TOWN AND COUNTRY PLANNING ACT 1990

Reference:	H08-0546-18	Date of Decision:	3rd September 2018
Applicant:	Mr D Scharff 59 High Street Gosberton Spalding Lincs PE11 4NJ		
Location:	59 High Street Gosberton Spalding		
Description:	Proposed residential dwelling

Front Elevation
1 : 100

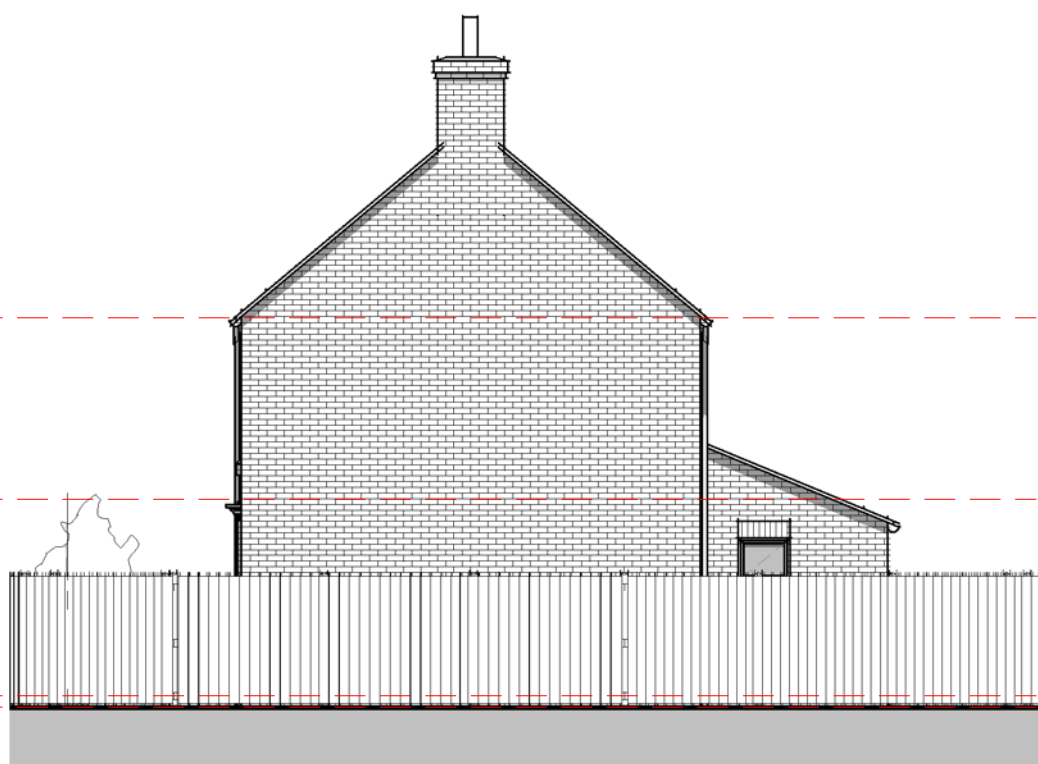
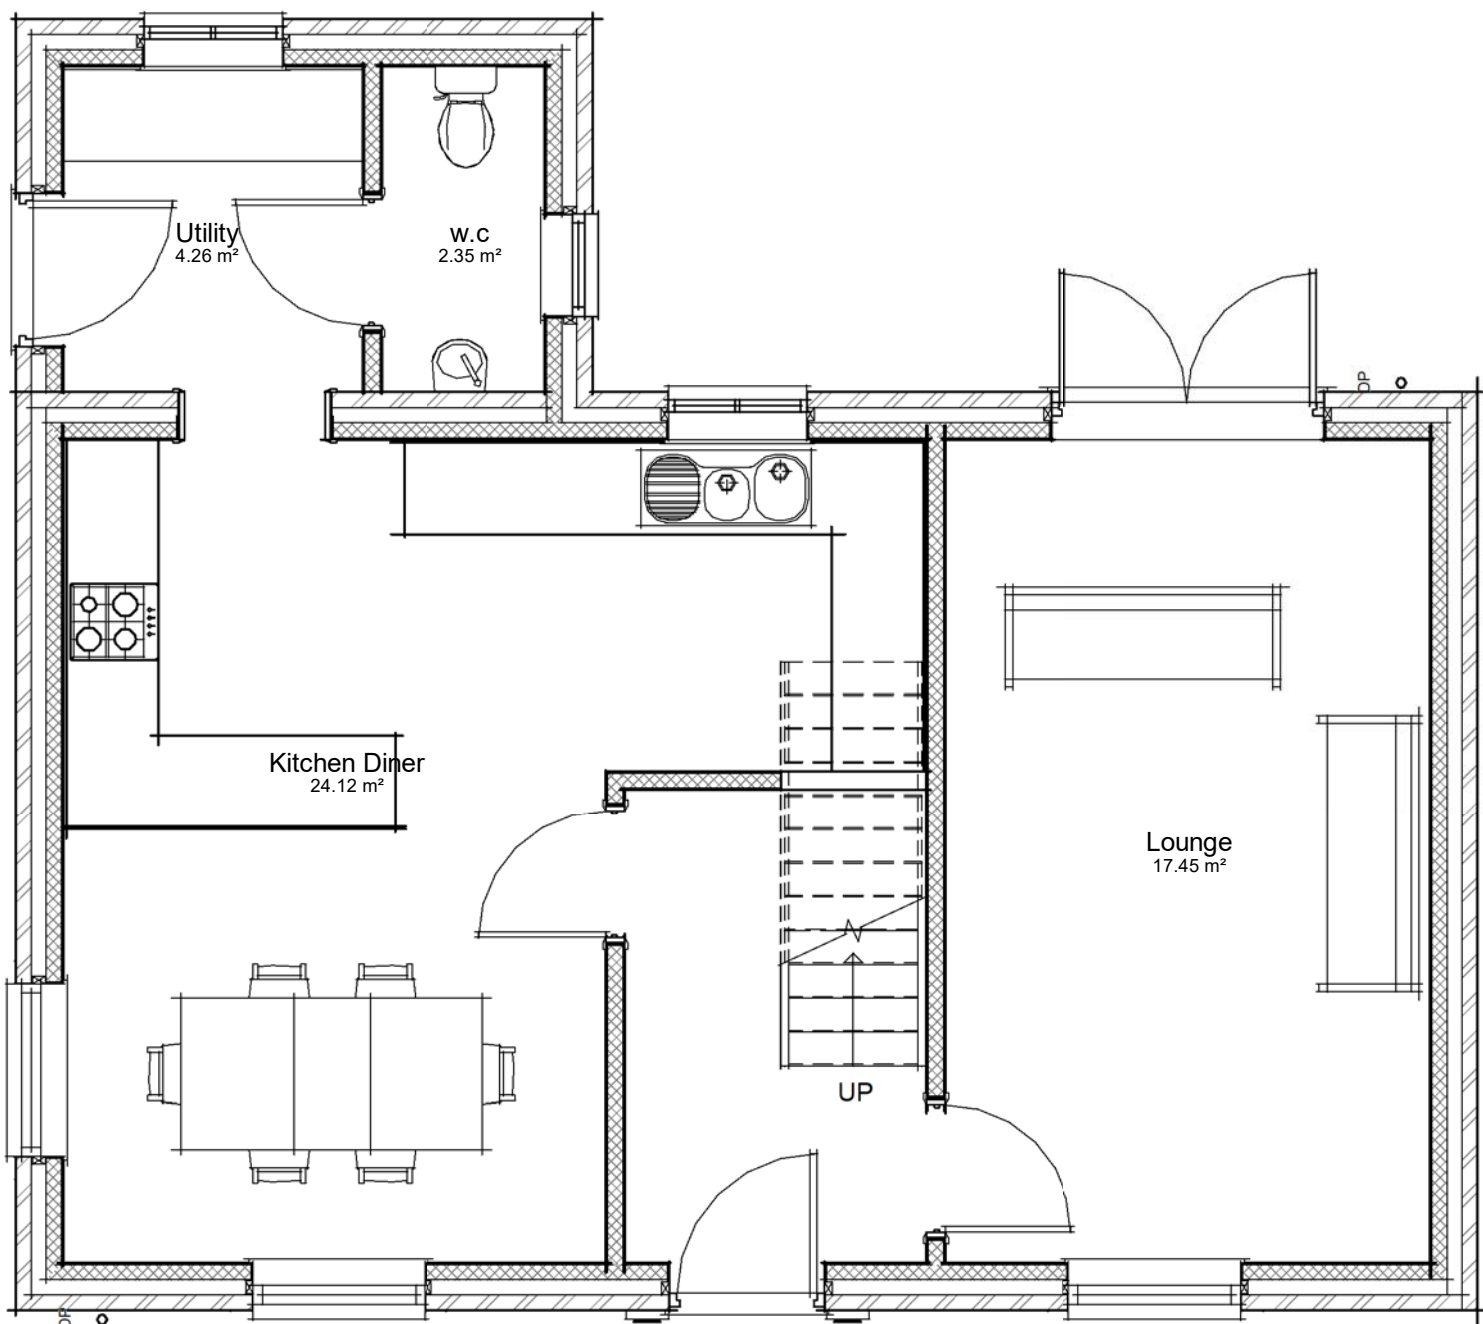
- 8 For the avoidance of doubt, the new windows to the south and west elevations shall be traditional, painted timber, box sliding sashes, set at least 10 cm in reveal, with the boxes recessed behind the masonry and the brick arch soffit exposed. The sashes shall have 2/2 panes, decorative horns, solid glazing bars with triangular putty effect glazing bead and full constructional details, at a scale of not less than 1:10, or full scale samples shall be submitted to and approved in writing by the Local Planning Authority before development is commenced. The windows shall be installed in accordance with the approved details and thereafter so maintained.

Note: The applicant is advised that traditional flush casement windows with solid glazing bars and putty effect glazing bead would be acceptable for use on the rear elevation, and that gauged brick arches should be used throughout to match the front elevation.

- 10 Notwithstanding the approved drawings, large scale details (at a scale of at least 1:10) of

the following features shall be submitted to and be approved in writing by the Local Planning Authority and no work shall commence in advance of that approval. These details shall provide for a cross sectional detailed drawing at 1:10 scale for each feature and the development shall be constructed in accordance with the details so approved:

- Door and window-head gauged brick arch, lintol and cill detail;
- Front door surround;
- Gable chimney stacks, to be taller and deeper than indicated so as to relate better to the proportions of the house.
